**Department of Defence**

**RE: SSD 7237 REDEVELOPMENT OF ARTHUR PHILIP HIGH SCHOOL AND  
PARRAMATTA PUBLIC SCHOOL**

14 June 2016

Shadow Diagrams

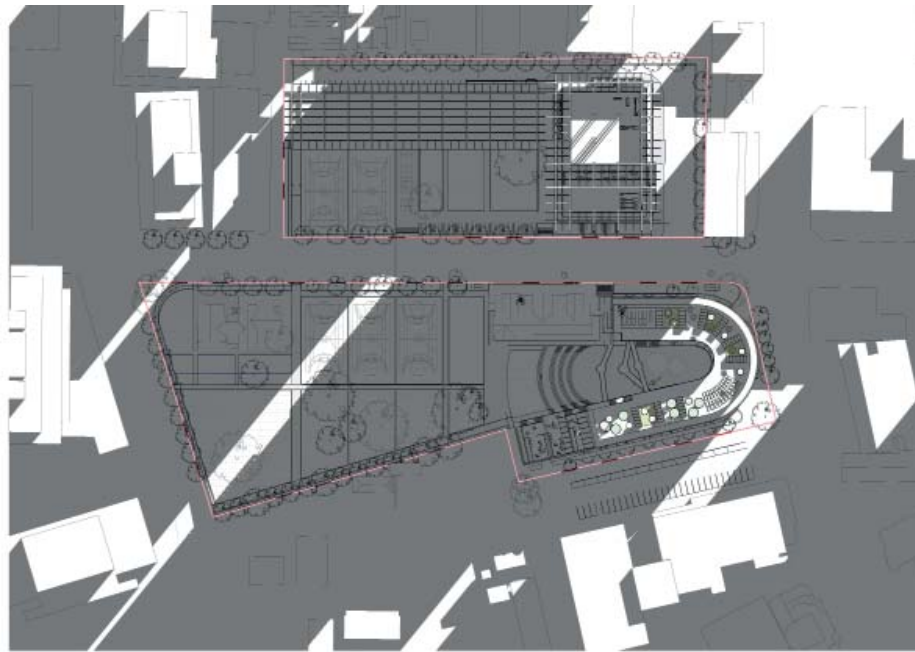
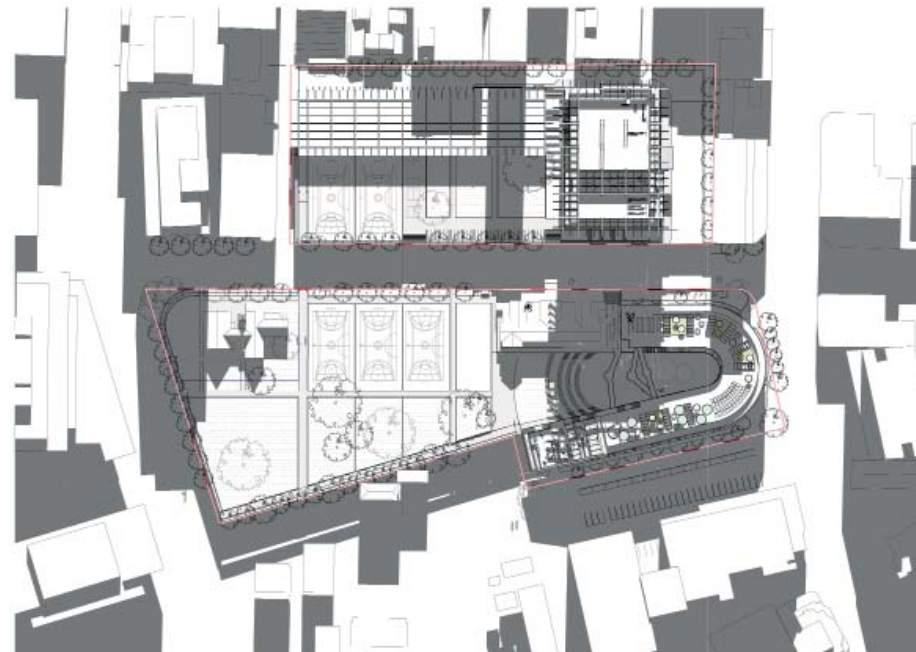
Defence is concerned that the proposed 17 storey building may cause overshadowing of the Lancer Barracks Precinct and requests that an appropriate assessment as to the impact of such overshadowing is appropriately assessed and considered.
